Subject: Form completion: Planning Application Comments Form

refNo: 3/2021/0076

addDev: Queen Mary Terrace & Bridge Terrace Mitton Road Whalley BB7 9JS

Project Name		Milton Road, Whalley	
Project Number		MR/W-SIS-PL01	
Scale	1:500	Date	18/10/2024
Author	SS	Checked	AS
Discipline	Planning	Version	F

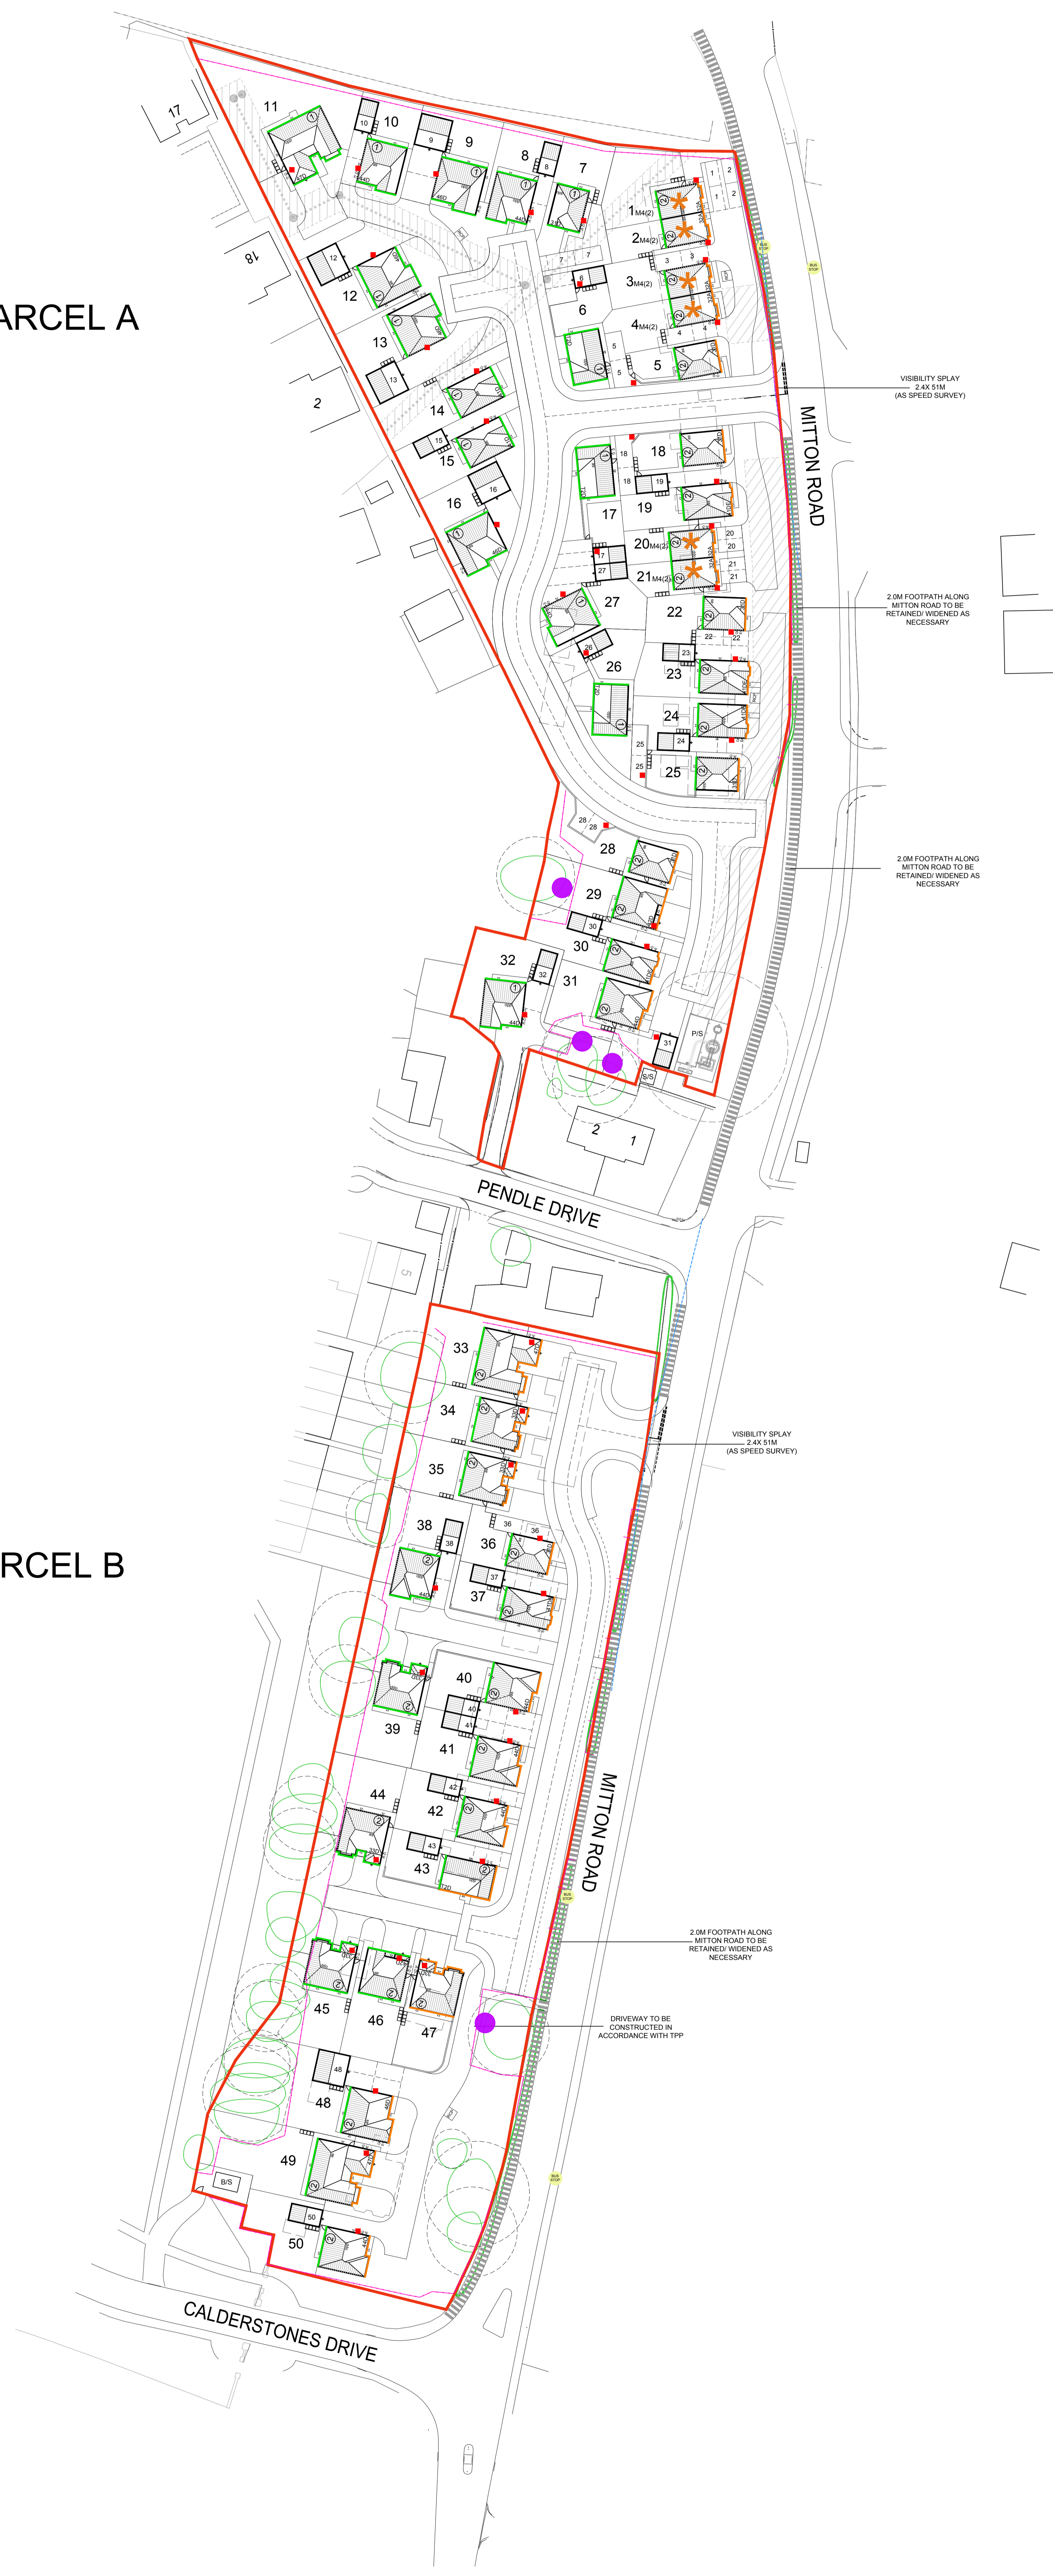
comments: Concern 1: Proposed site plan 1 does not identify the 2 trees in the garden of the property at [REDACTED]. At least one of these trees has a preservation order in place, as identified in the land search at the time of purchase (2008). Canopy & root protection area does not appear to be accounted for when considering plot 38 of the development. As a minimum we would suggest that the driveway and house is swapped position from that of the current plans. The driveway will not require footings, whereas the house will obviously require foundations that will interfere with said protected tree (per plan 1). Concern 2: Potential for additional flooding risk to the property at [REDACTED]. The adjacent field currently has a French drainage system which is arguably already inadequate. Additional properties may exacerbate this further. The current private road also sees significant drainage issues. Please ensure substantial (i.e. more than is merely permissible) drainage is factored into the plans.
